From: Bloomer, David <David.Bloomer@lancashire.gov.uk>
Sent: 09 September 2016 11:21
To: Rebecca Halliwell
Cc: LHS Customer Service; planning
Subject: app3/2016/0794 Providence House, Preston Road

Proposed site plan

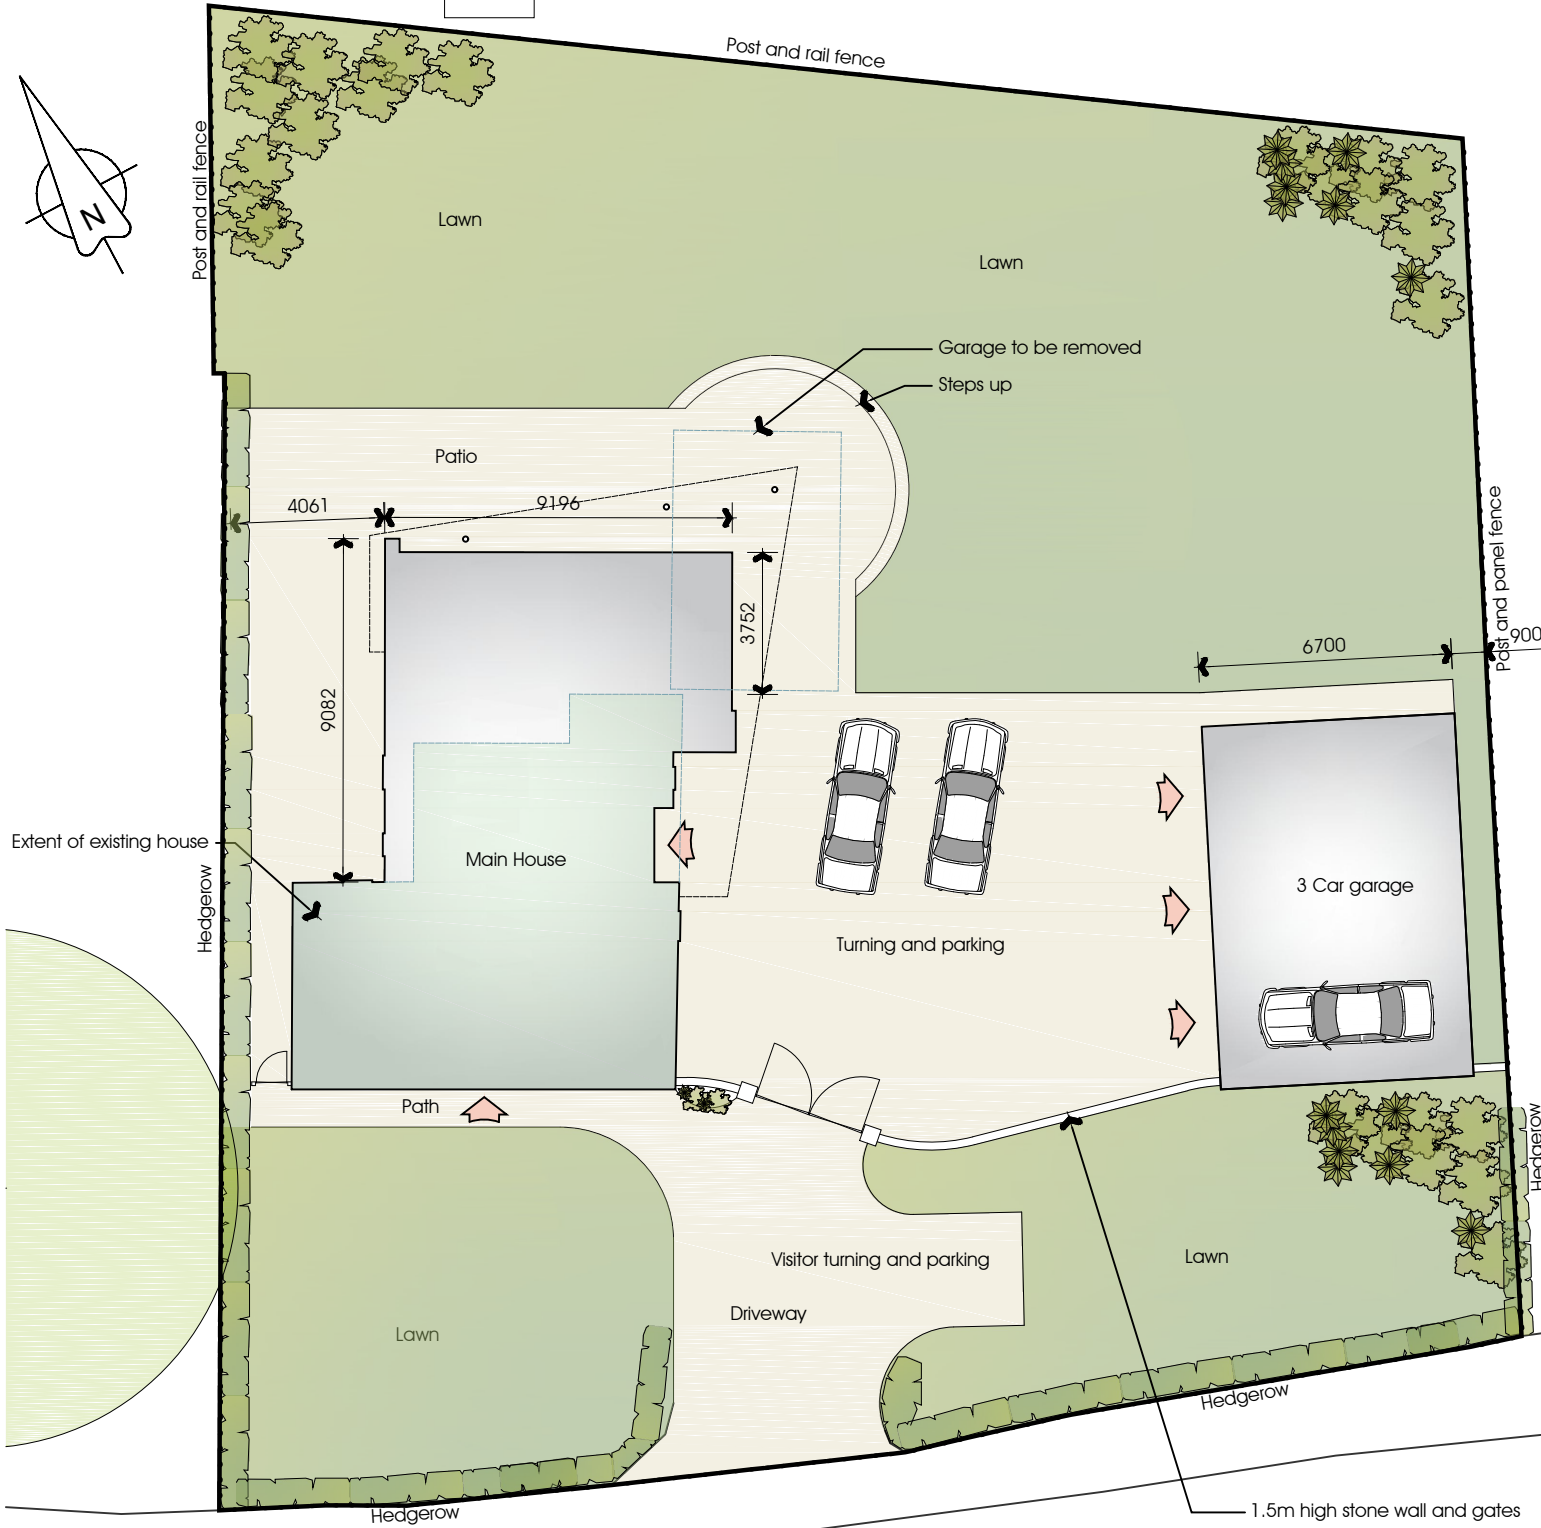
In 2015 an application was submitted to replace the existing building with a 5 bed dwelling (app 3/2015/0019) the proposal was considered acceptable by the highway authority as the proposals also included a relocation of the existing access further west which would improve the sightlines to the west.

The applicant notes that the current national speed limit will be reduced to 40mph. The proposals have been advertised and the reduced speed limit will be implemented in due course. I would dispute the comment that "approval" has been given for the erection of a traffic mirror, speaking to a colleague, the highway authority would raise no objection to a traffic mirror being erected at the applicants expense but this would need to be erected on private land and subject to removal if it proved to be a hazard to highway users. Having visited the site , the mirror would have to be erected in the field opposite behind the hedge which would reduce its effectiveness. Notwithstanding these points the current proposal would retain the existing access and increase the number of beds from 2 to 4. The potential being an increase in vehicular movement to and from the site which due to the poor sight lines would be potentially hazardous to road users. The recommended sightlines for a 40 mph road (Design Bulletin 32) is 120 m. at the existing access sightlines of 2x 47 are achievable to the west whereas if the access was relocated as per the 2015 application this would increase to 2x60m. Although the required sightlines of 120m would not be achievable the relocation of the access would provide a betterment which would offset the additional bedrooms / traffic generation.

As submitted the application would not be acceptable due to the highway safety concerns outlined above, however should the applicant relocate the access as per the 2015 application I would be prepared to reconsider my recommendation.
